Reference No:	2022/62/93750/W
Site Address:	479, New Hey Road, Salendine Nook, Huddersfield, HD3 3XG
Description:	Erection of a rear dormer and a single storey rear & side extension with disabled ramp.
Recommending Officer:	Sam Jackman

DECISION – Conditional Full Permission

Officer Report – 2022/93750

Note:

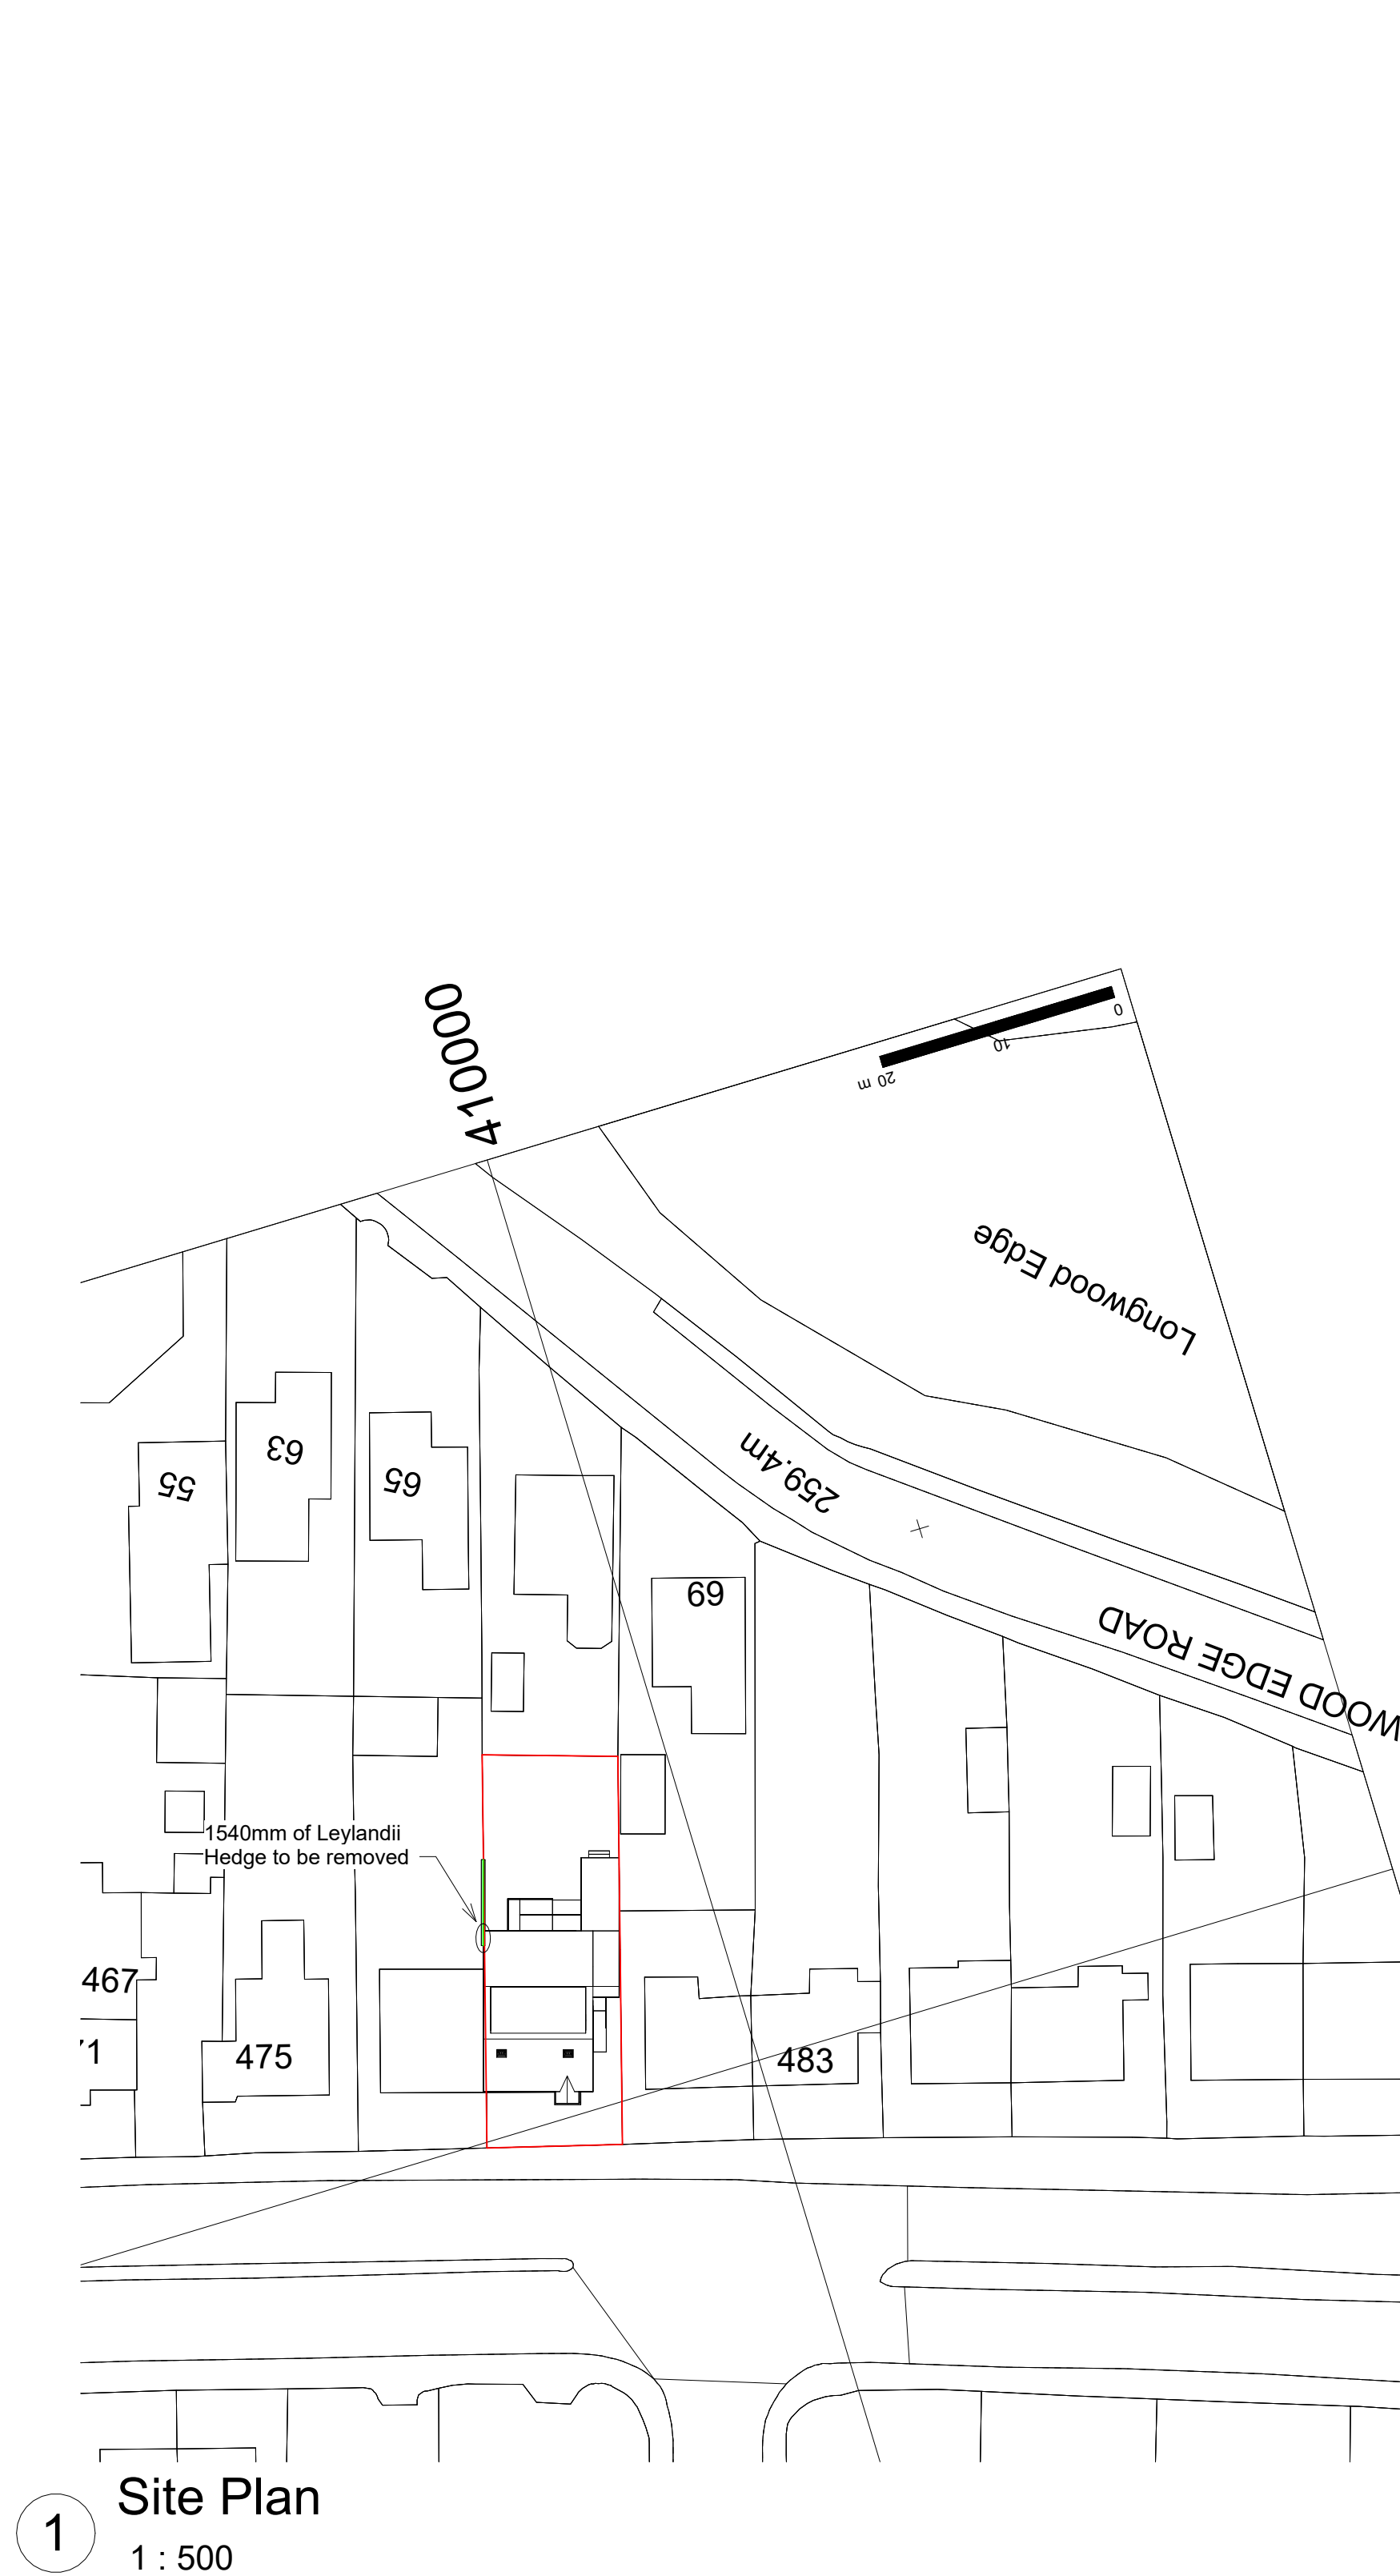
- The existing wall for the conservatory will be retained on the boundary with No. 477 and the extension will then be set in 0.15m for the remaining 1.54m, where the existing hedge will be removed retaining the remainder.

Further amendments have been received to replace the flat roof over the utility with an asymmetrical dual pitched roof, the eaves lowered for the rear elevation and the disabled ramp having clear top & bottom platform areas, along with steps shown from the rear elevation of the existing storeroom.
